Georges River Council Advice on EIS – St George Private Hospital (your reference: SSD-86969958)

Georges River Council welcomes the opportunity to comment on the Environmental Impact Statement (EIS) for the State Significant Development application (SSDA) associated with the proposed St George Private Hospital Expansion in Kogarah.

DRAWING
GENERAL ARRANGEMENT PLAN: SITE B - BANK LN
GROUND FLOOR PLAN

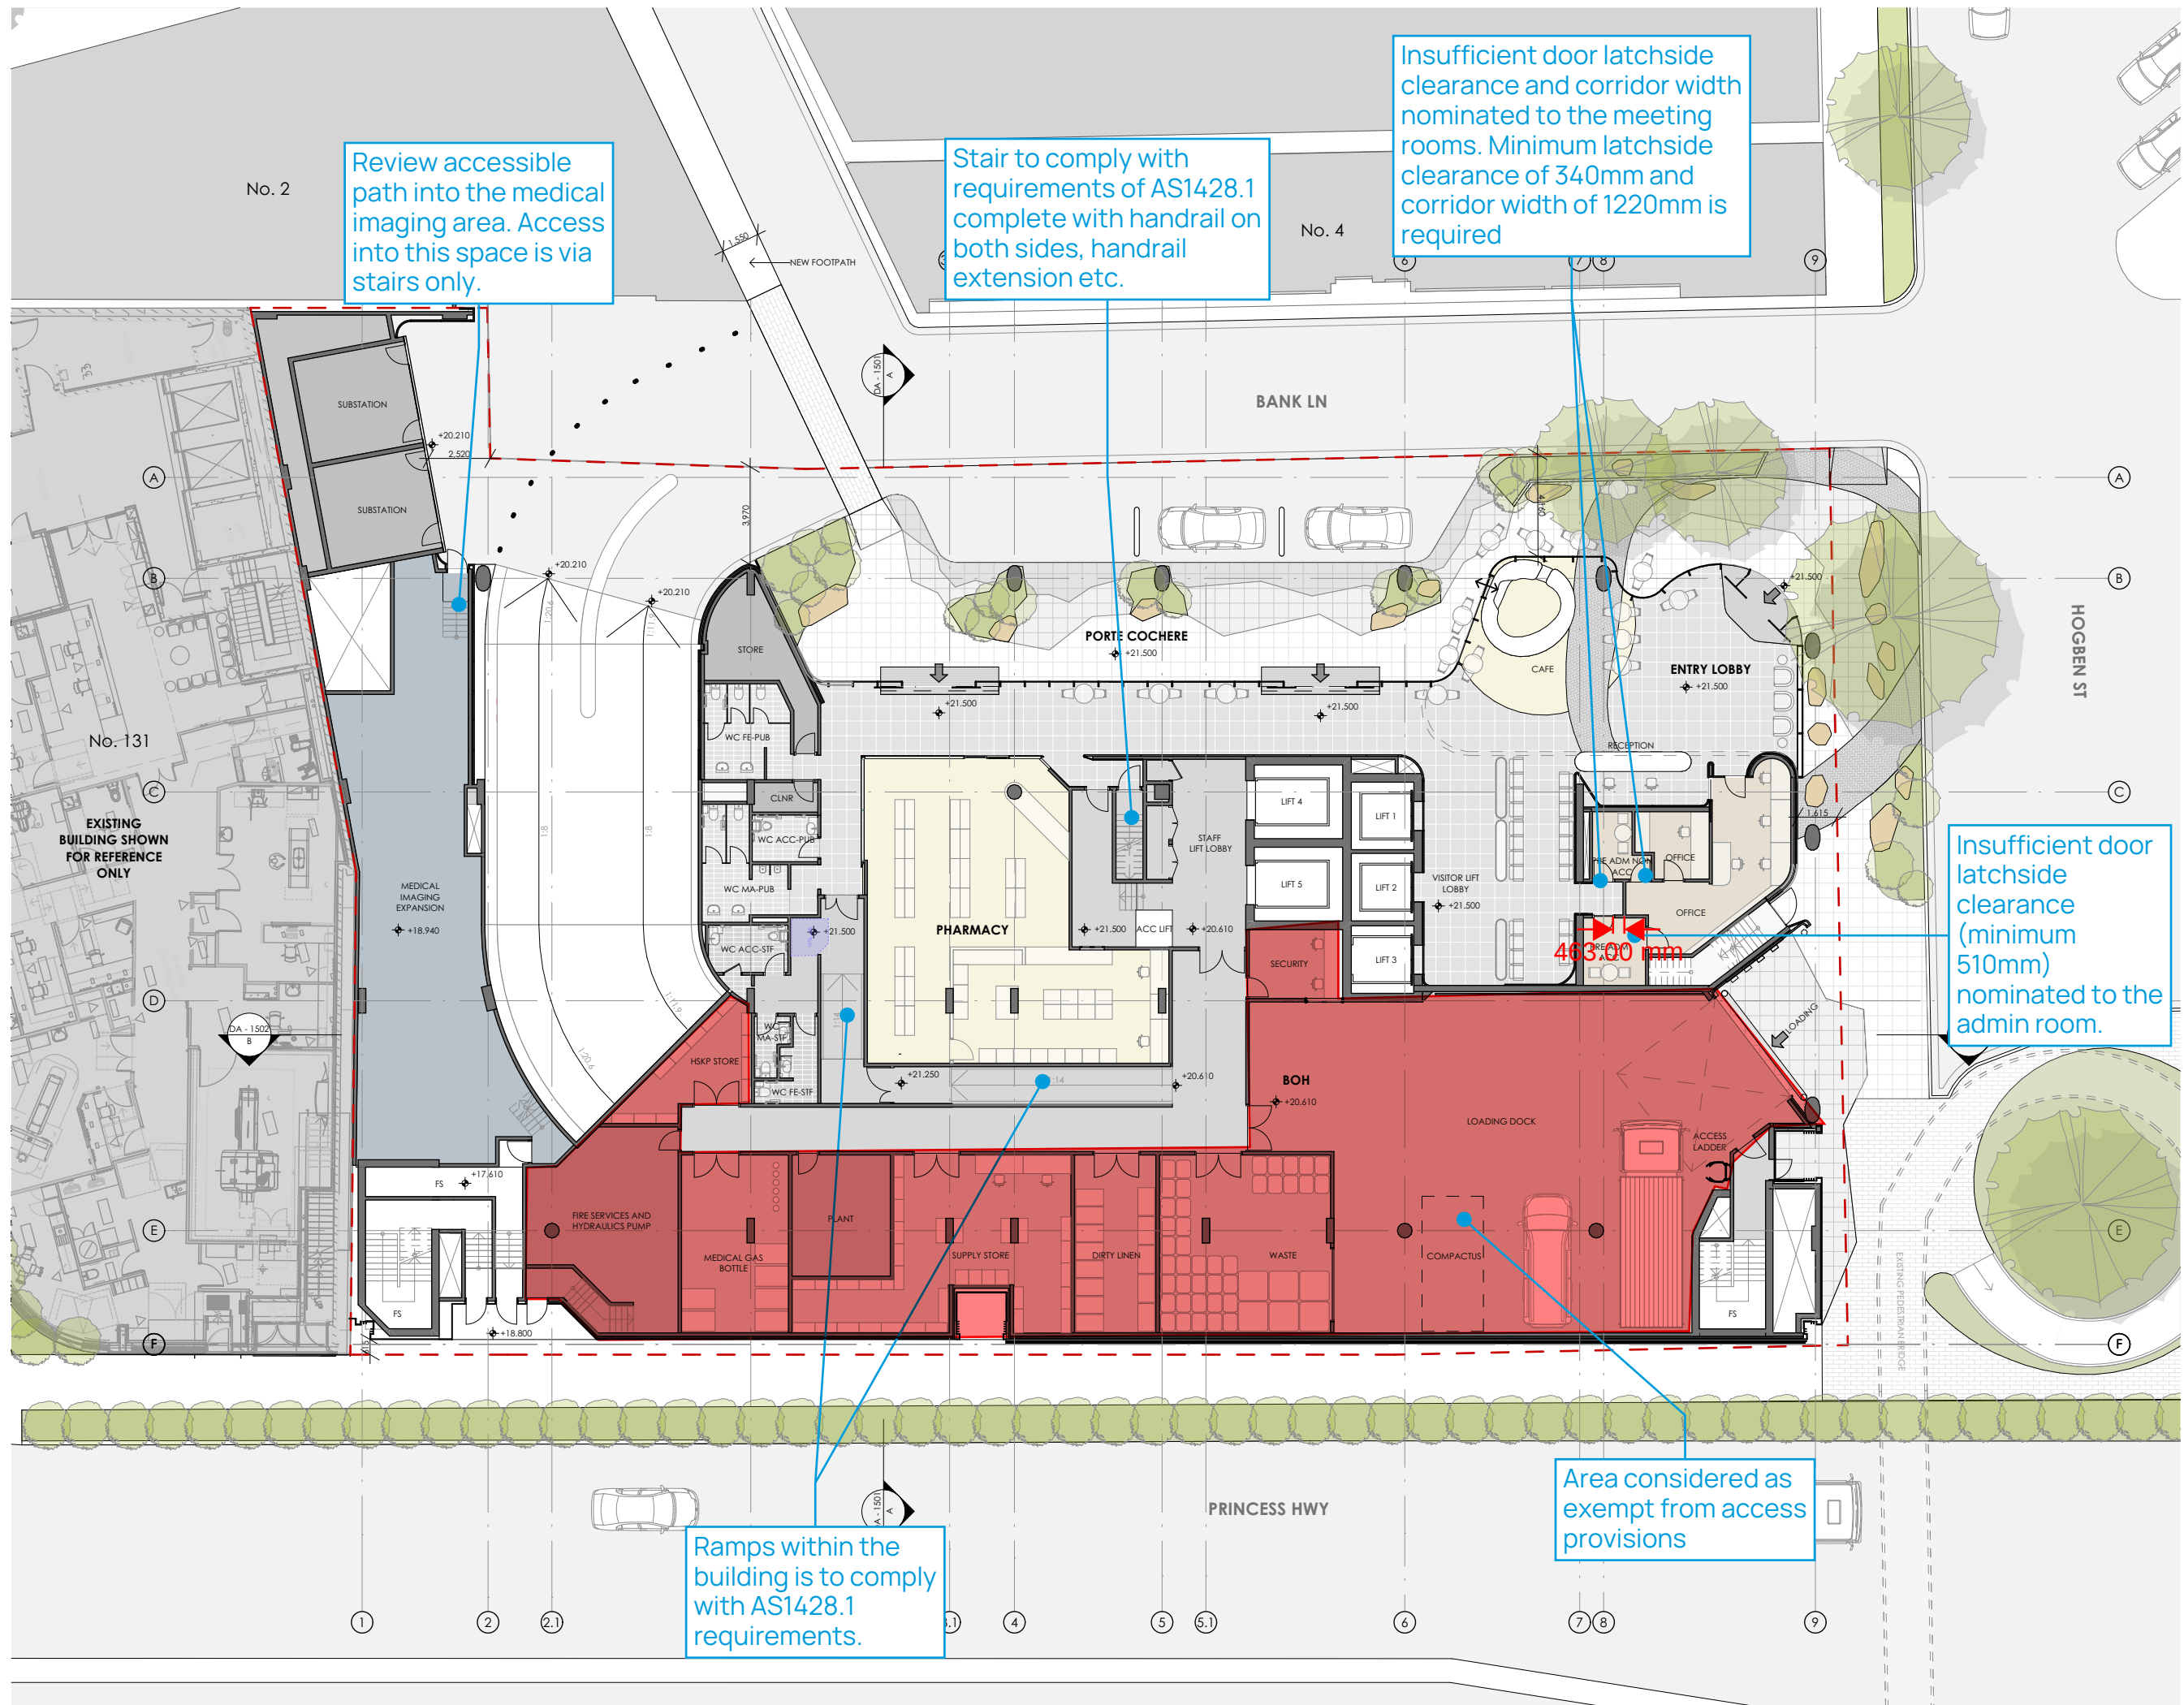
The plans show the footpath, basement car park, and drop-off zone built entirely within the private site boundary, contrary to the intent of DCP controls. Private land pedestrian treatments, while beneficial, do not meet the requirements for public dedication, nor do they provide long-term certainty for public access.

- Demonstration of emergency access to adjoining property and substations via the bollarded section to be shown.
- Clear line-marking to reinforce one-way flow of Bank Lane is to be included to prevent illegal U-turns from the Porte Cochere area.
- Parking controls that are proposed for the Porte Cochere area must be defined and enforceable. The controls need to be indicated e.g. short-term parking, no parking.
